Single storey side/rear extension, part two storey rear extension rear extension, raising of roof height to create a second floor and front double garage.

56 Angmering Lane East Preston Littlehampton

Planning Application EP/37/20/HH

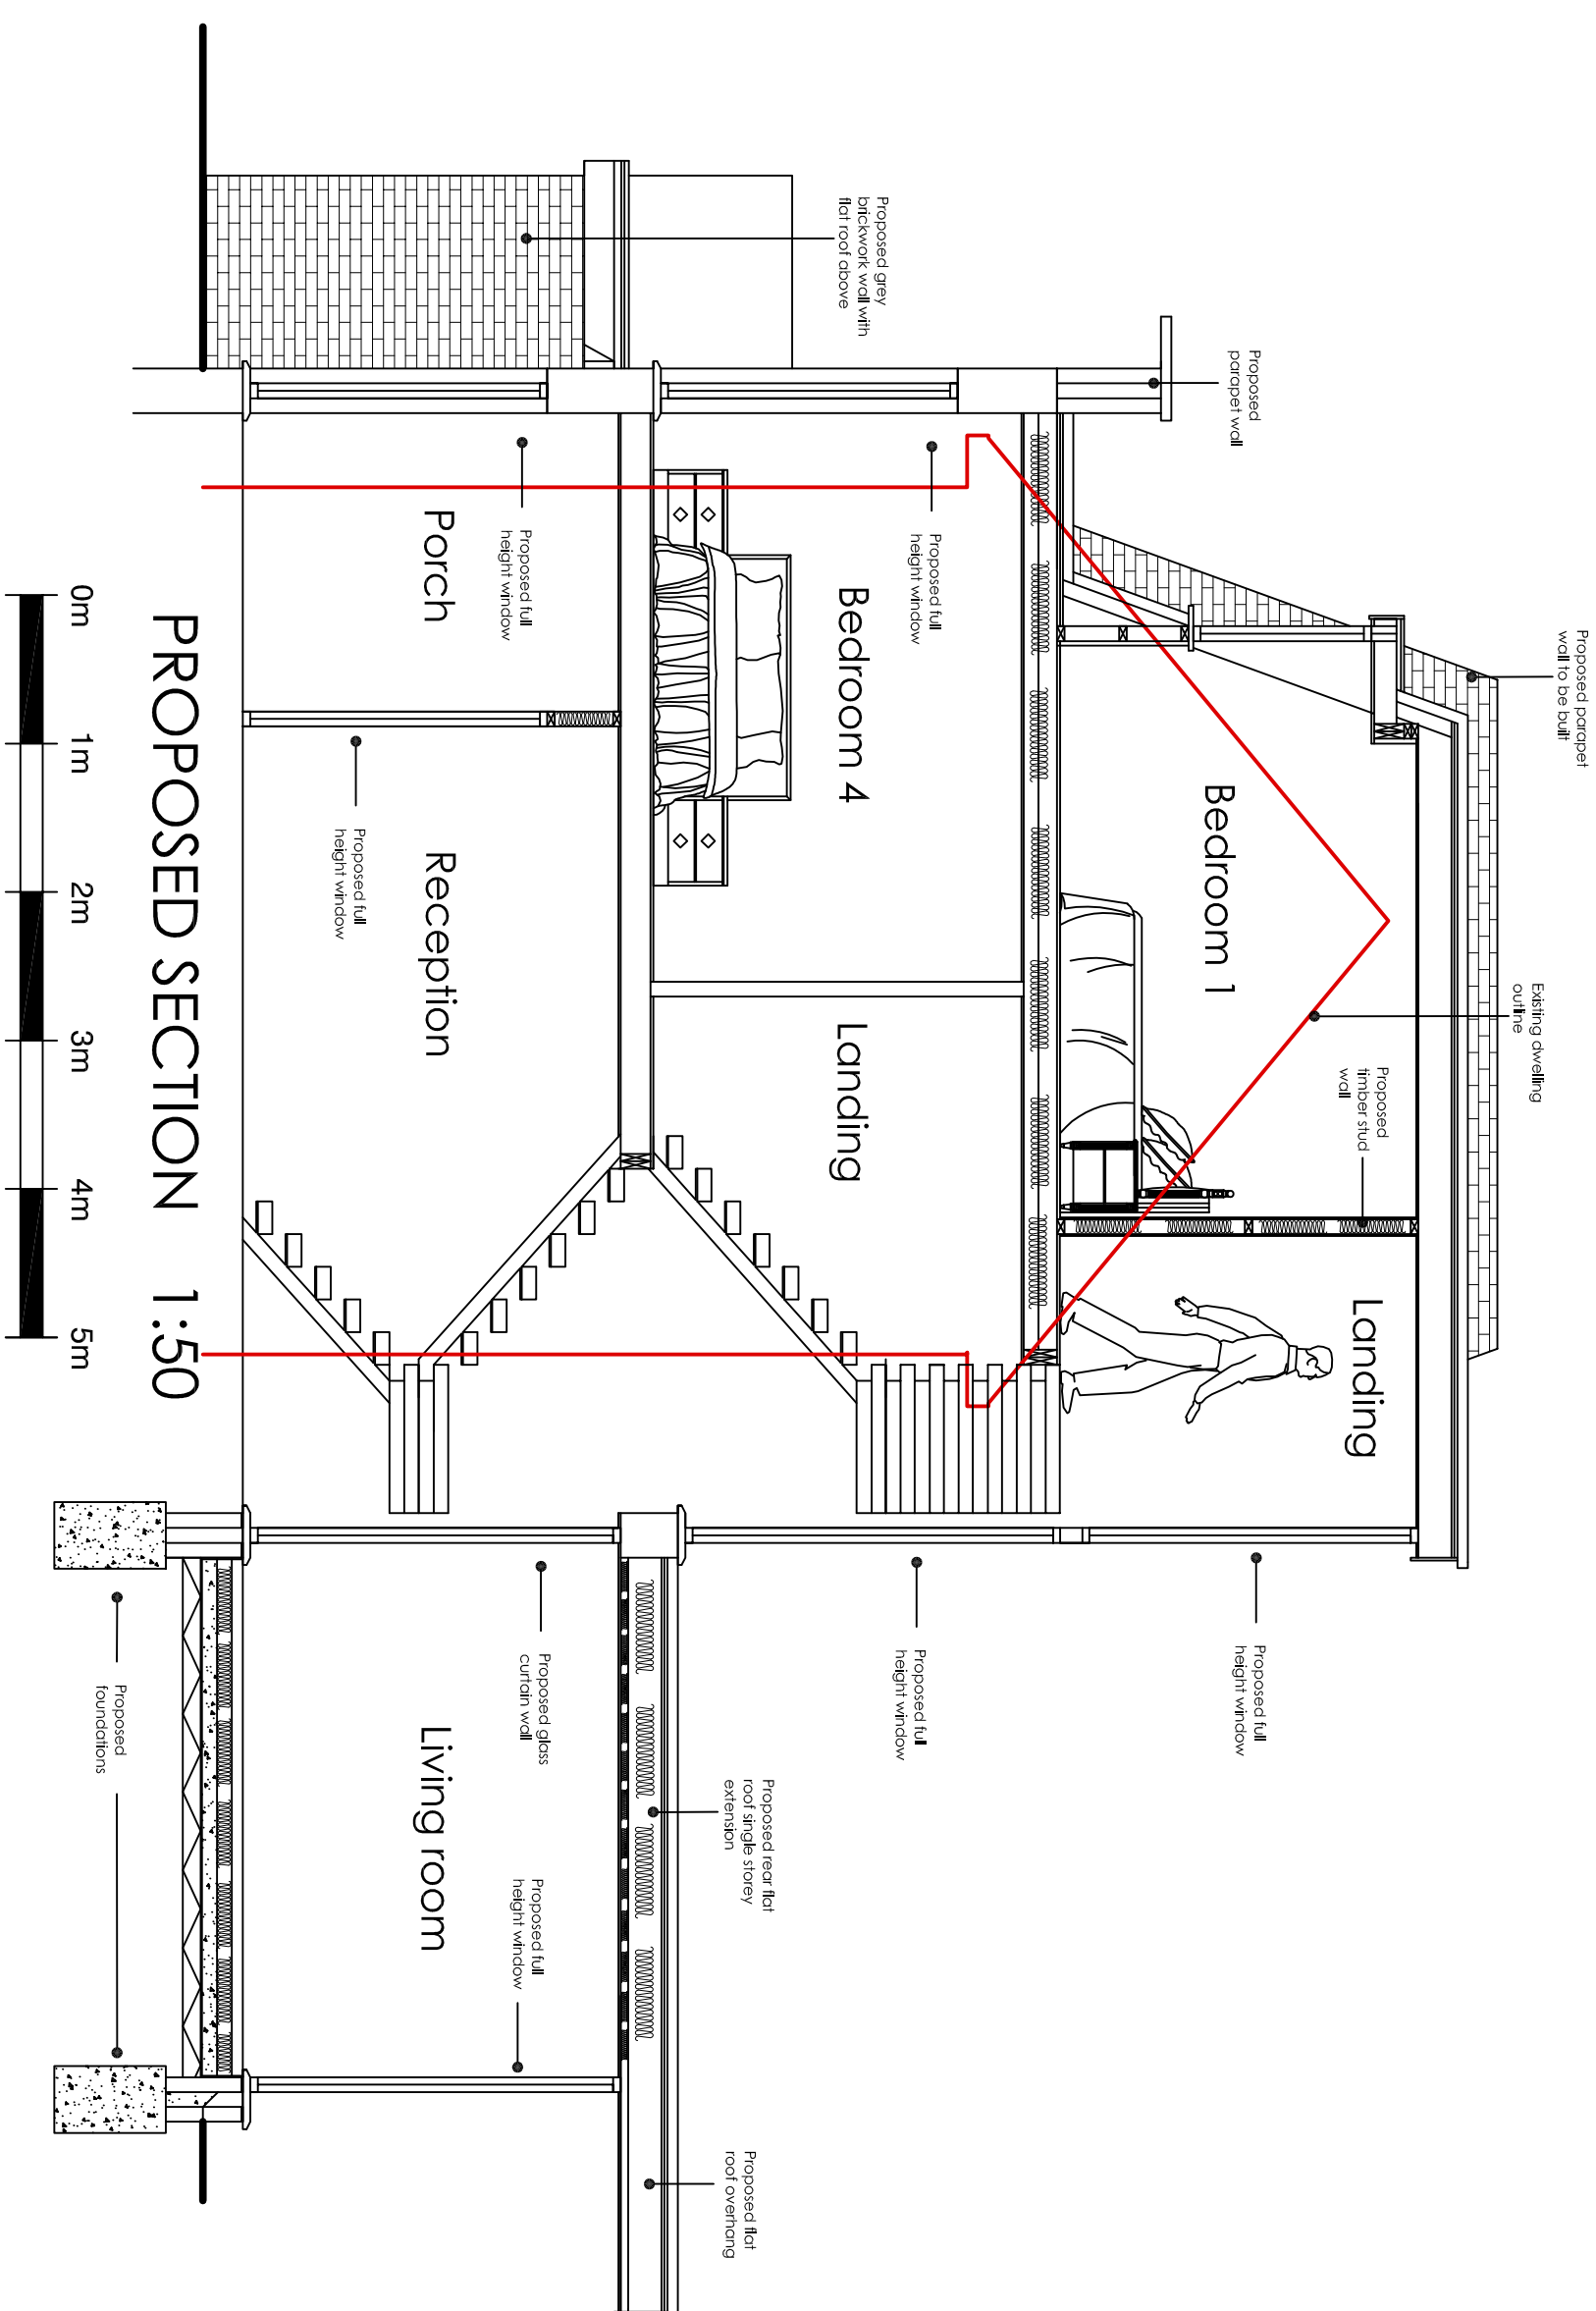
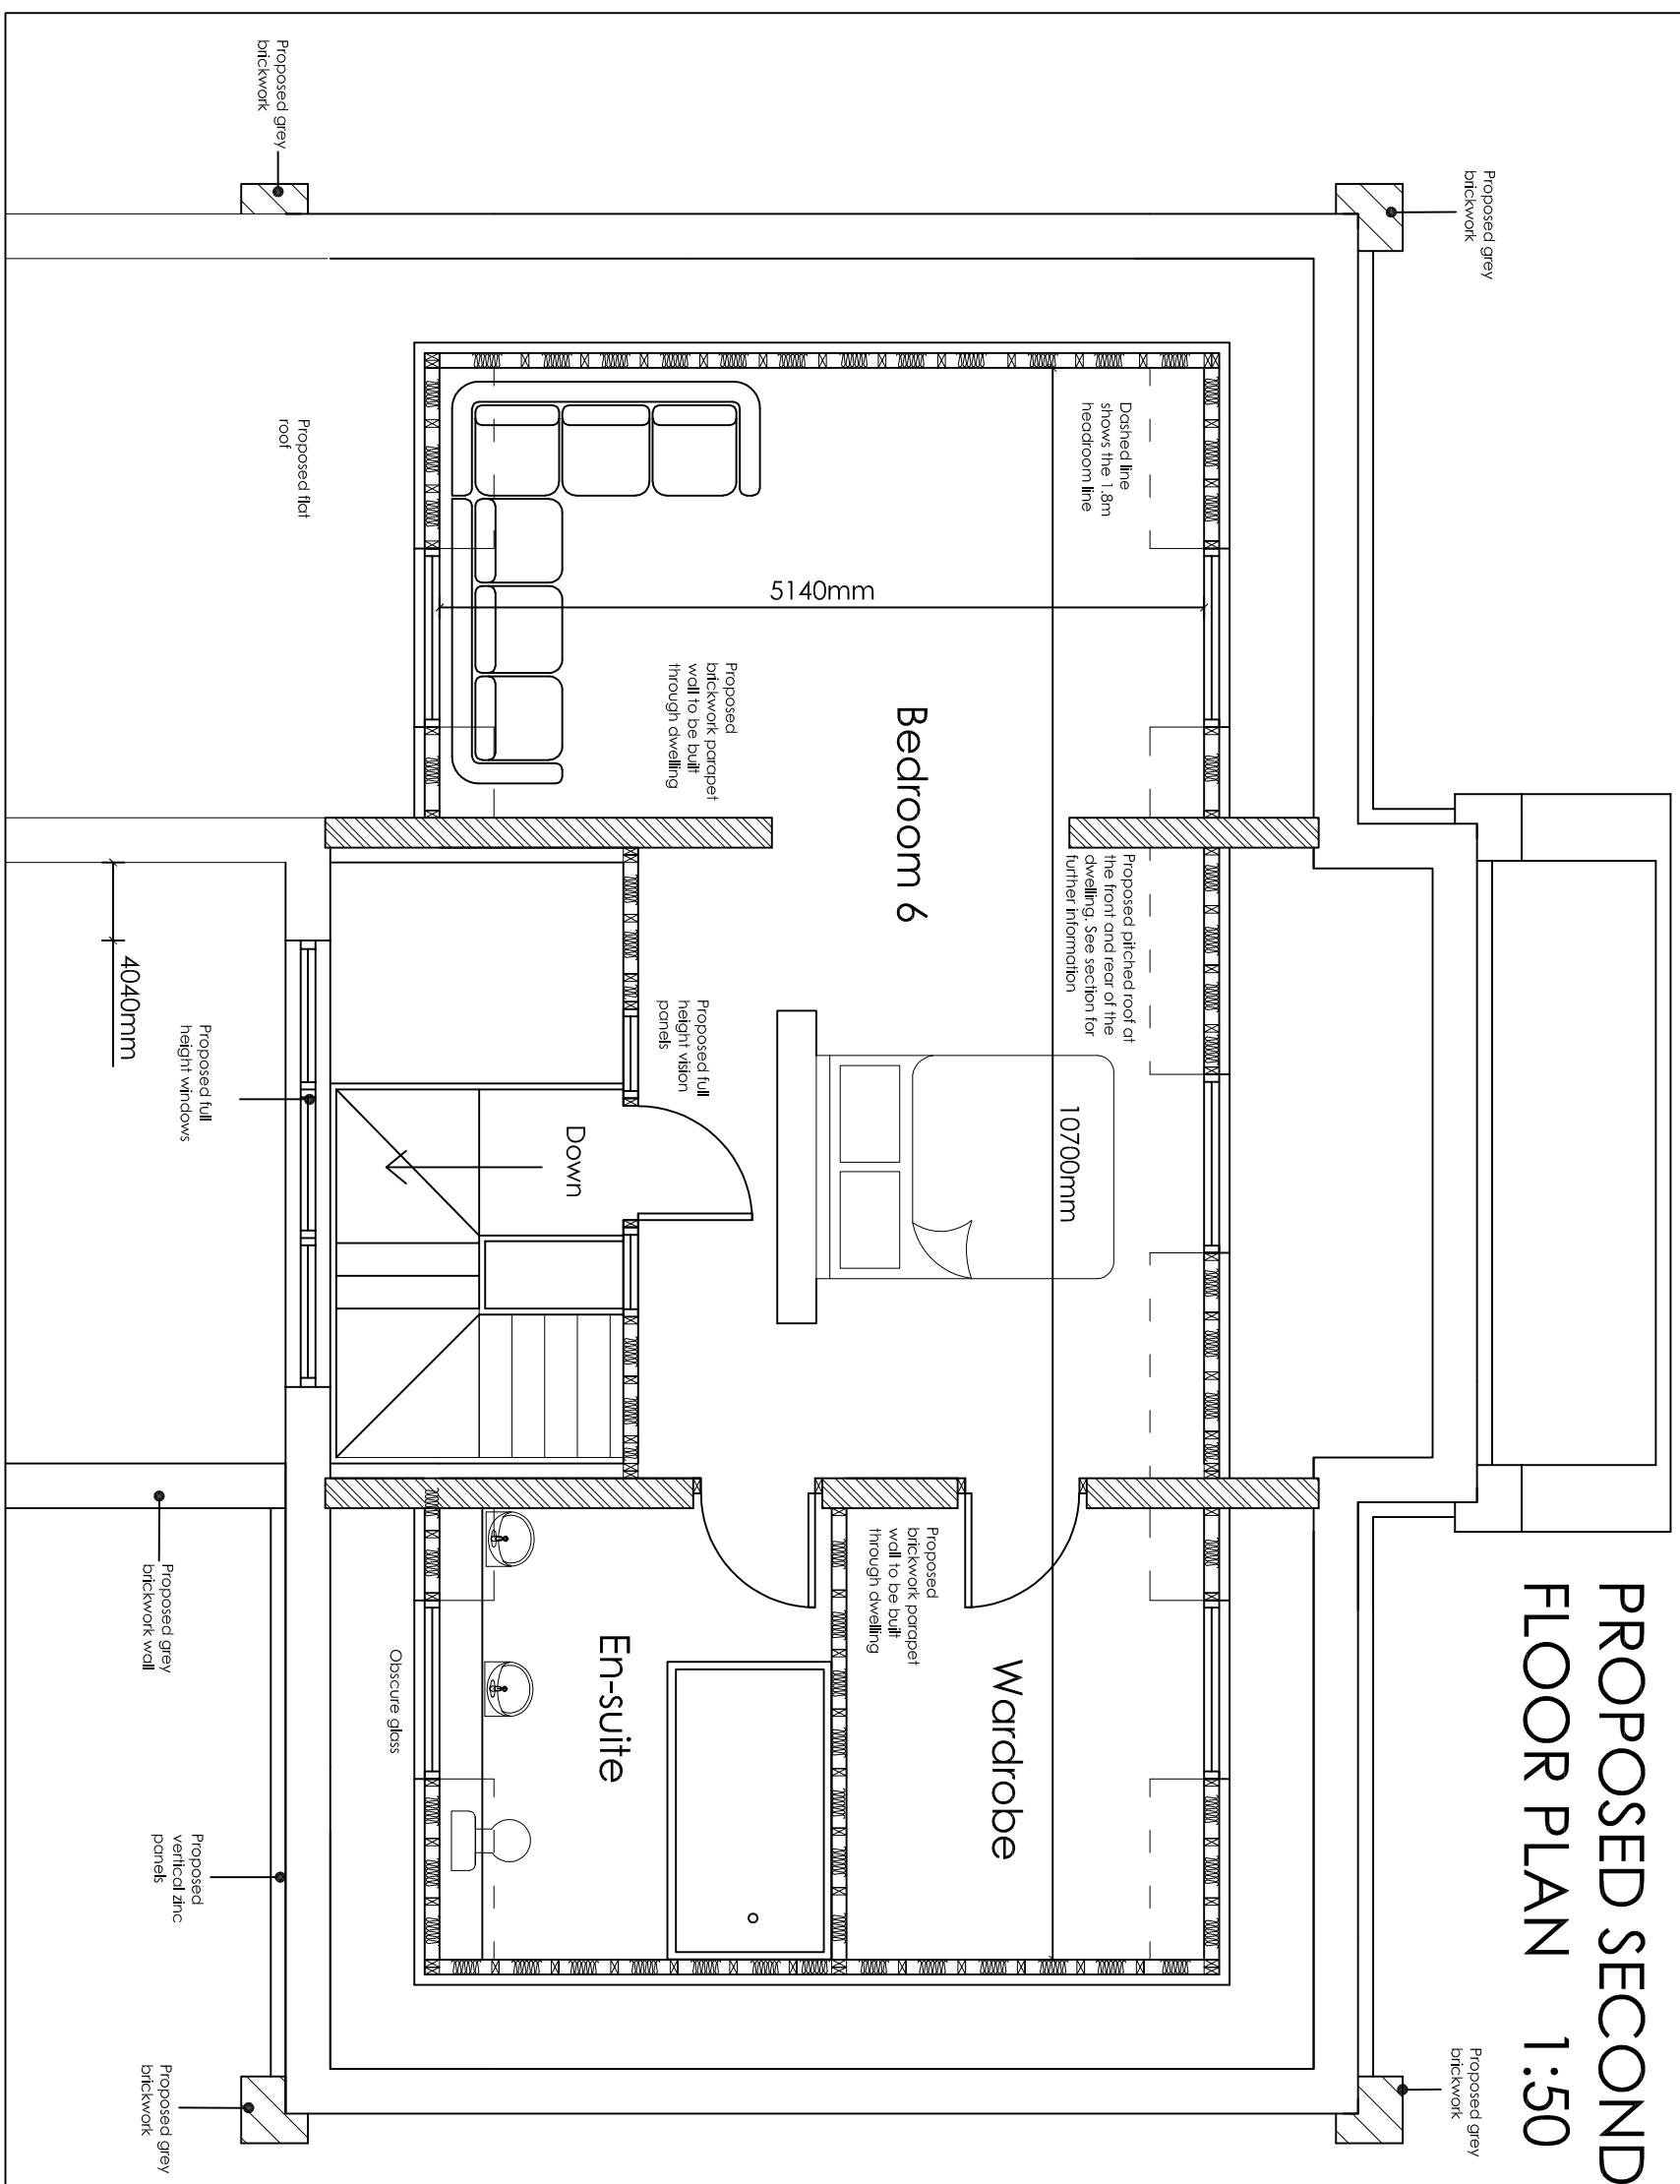
The proposed building with its flat roof finishes well above the existing roof ridge line, it would give the building the appearance of looking like a small apartment block and would look unsightly at this end of Angmering Lane, it would be higher than all the surrounding houses, being so high would infringe on the privacy of our property.

The proposed detached double garage which is to be sited in the front garden of the house is again completely out of character and far too close to the road, and for us living directly opposite would be quite unsightly.

The sheer size of the proposed development compared to the existing property is a clear case of over developing of a small plot which would take away the character of this part of Angmering Lane and indeed the whole of the Willowhayne estate.
